Application no: **3/2021/0875**

Address: **Sunnymede Ribblesdale Avenue Clitheroe Lancashire BB7 2HZ**

Proposal: **Proposed erection of a detached two and half storey dwelling with garden and driveway and new access.**

The Local Highway Authority have viewed the plans and highway related documents and have the following comments to make:

5934 - 01-02 B

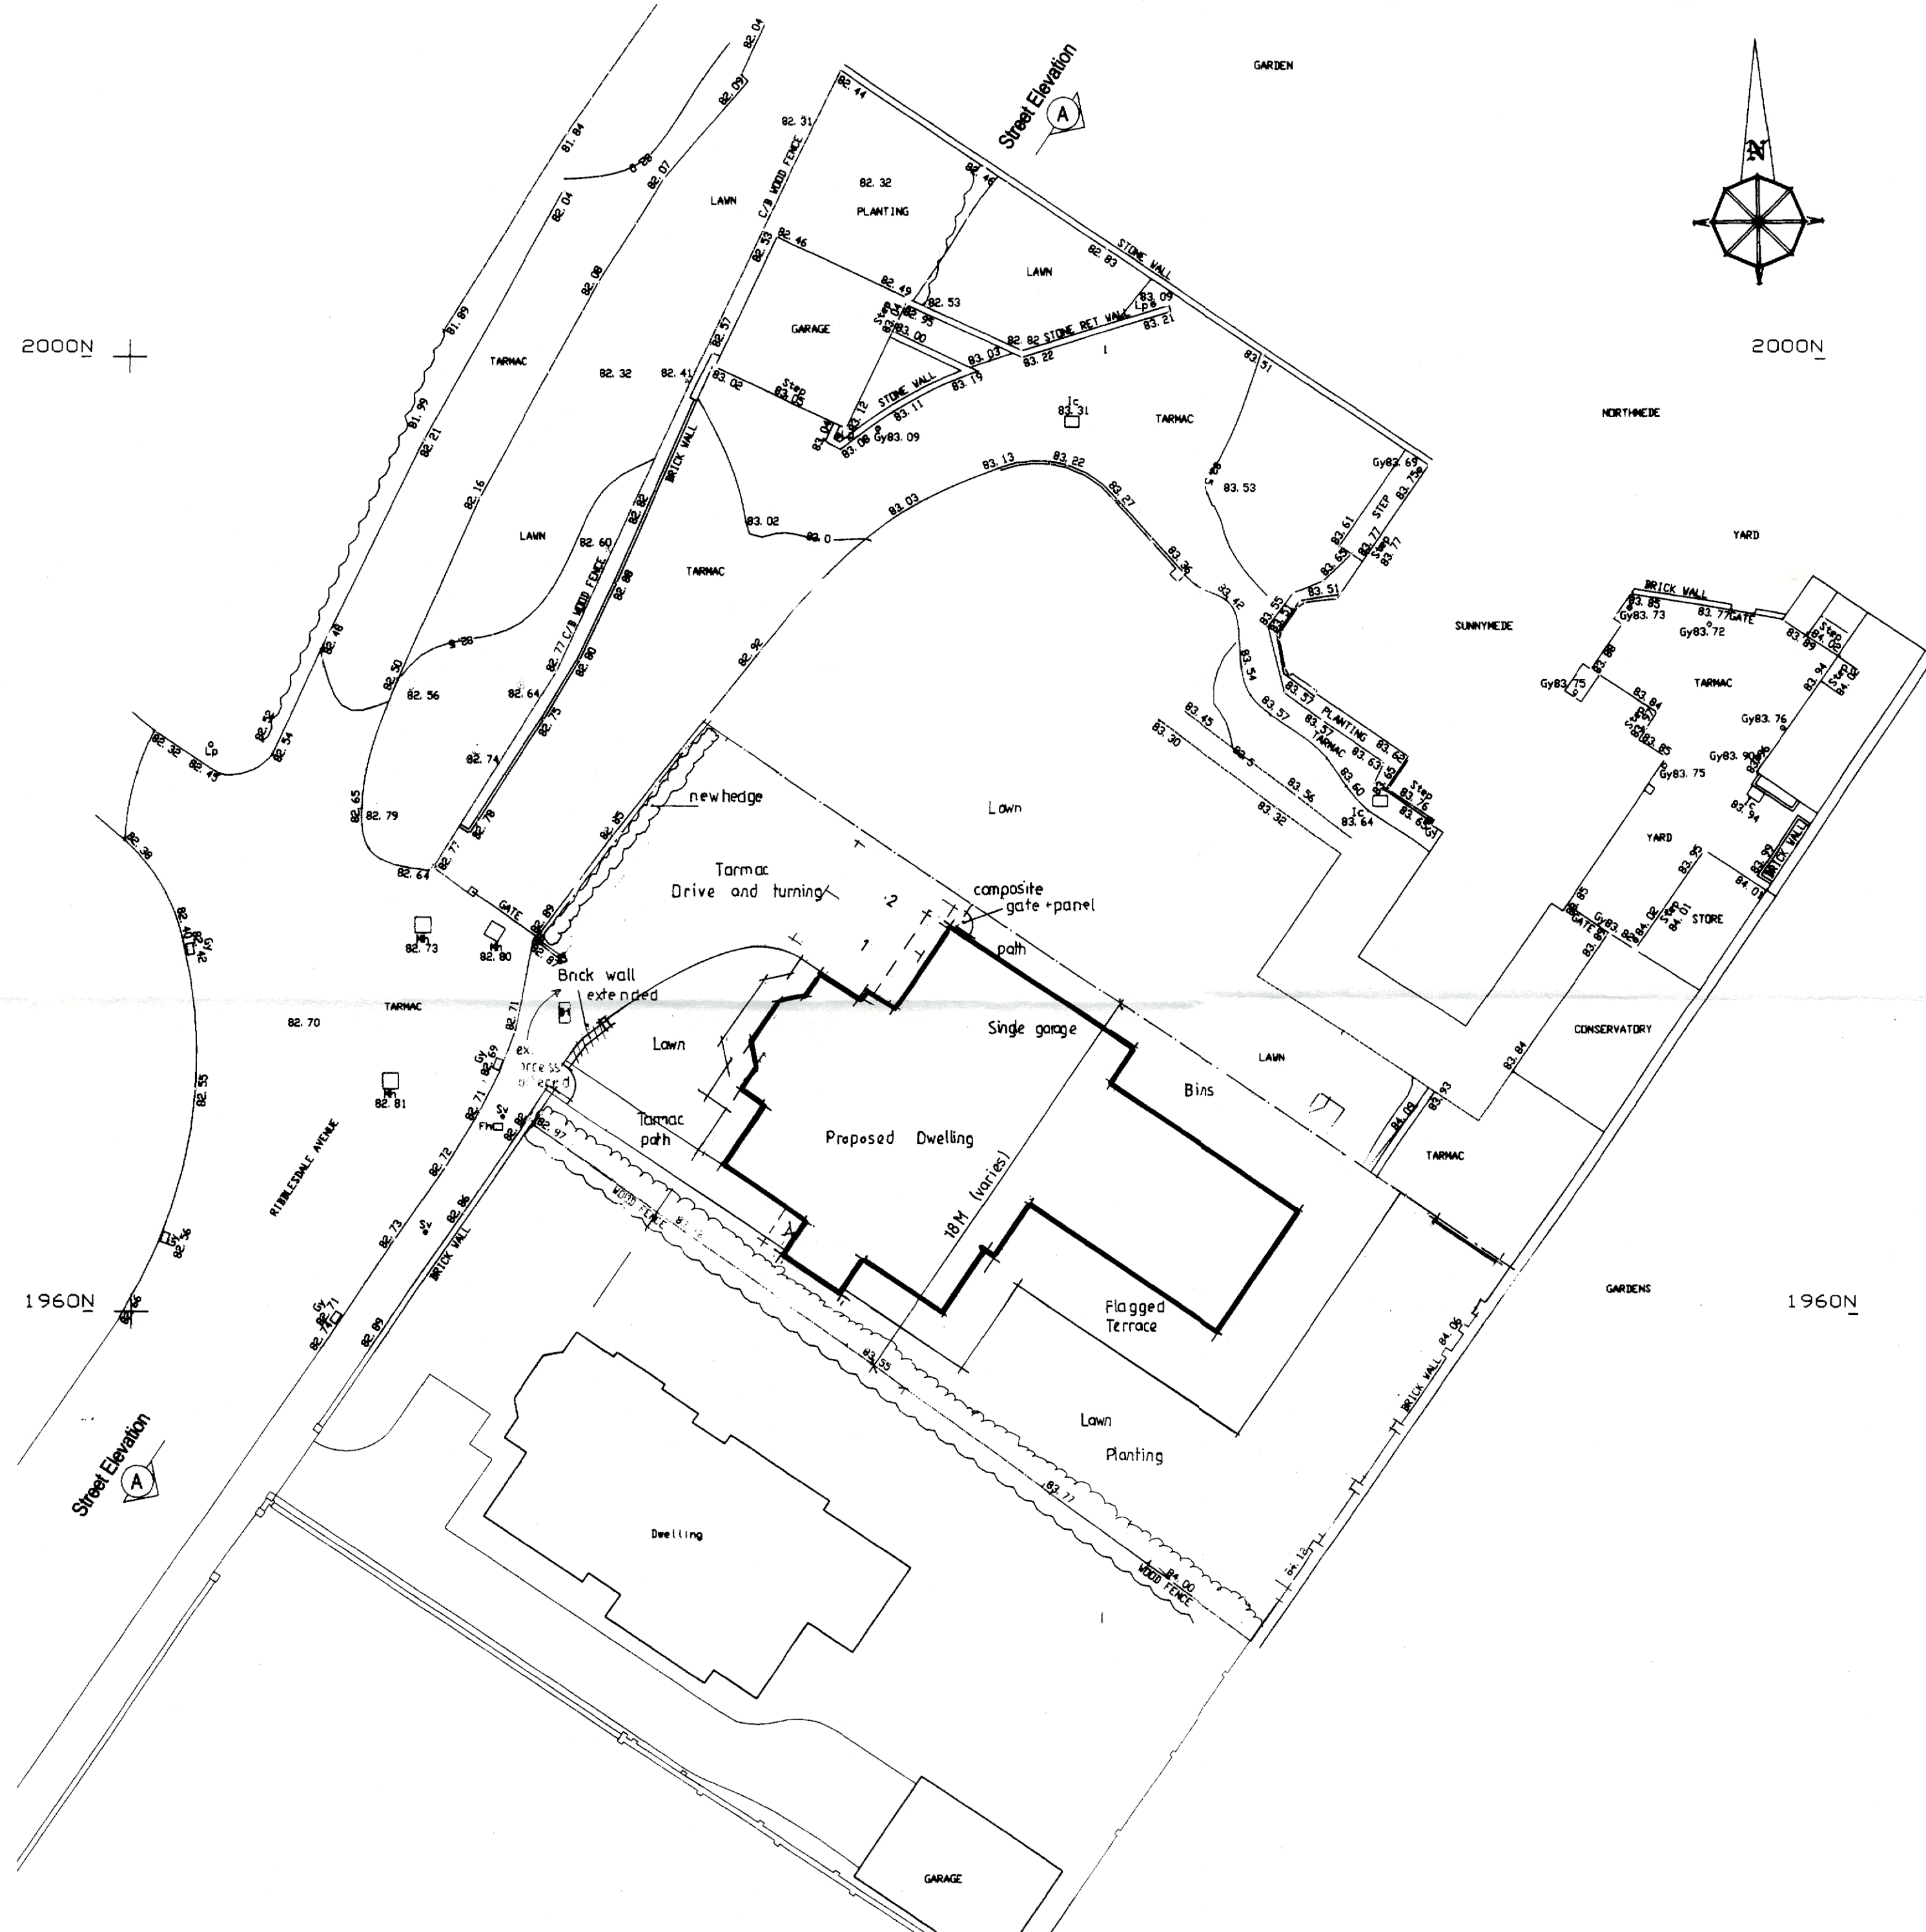
The LHA have reviewed SPA drawing number 5934-01-02B titled "Proposed Site Plan" and are satisfied that the access arrangements complies with the LHAs guidance and so have no further comments to make.

The LHA, however, make the Applicant aware of the existing service chamber which is located in the centre of the proposed access. Should the proposal be approved, subject to consultation with the appropriate telecommunication company, the Applicant will be liable to the full cost of relocating the service chamber further along Ribblesdale Avenue or liable to the full cost of strengthening the chamber.

The LHA have reviewed SPA drawing number 5934-01-02B titled "Proposed Site Plan" and are satisfied that the site complies with the Joint Lancashire Structure Plan and so have no further comments to make.

1. No part of the development hereby permitted shall be occupied until such time as the access arrangements shown on SPA drawing number 5934-01-02B have been implemented in full.

2. No part of the development hereby permitted shall be occupied until such time as vehicular visibility splays of 2 metres by 43 metres have been provided at the site access. These shall thereafter be permanently maintained with nothing within those splays higher than 1 metres above the level of the adjacent footway/verge/highway.

3. The development hereby permitted shall not be occupied until such time as the parking and turning facilities have been implemented in accordance with SPA drawing number 5934-01-02B. Thereafter the onsite parking provision shall be so maintained in perpetuity.
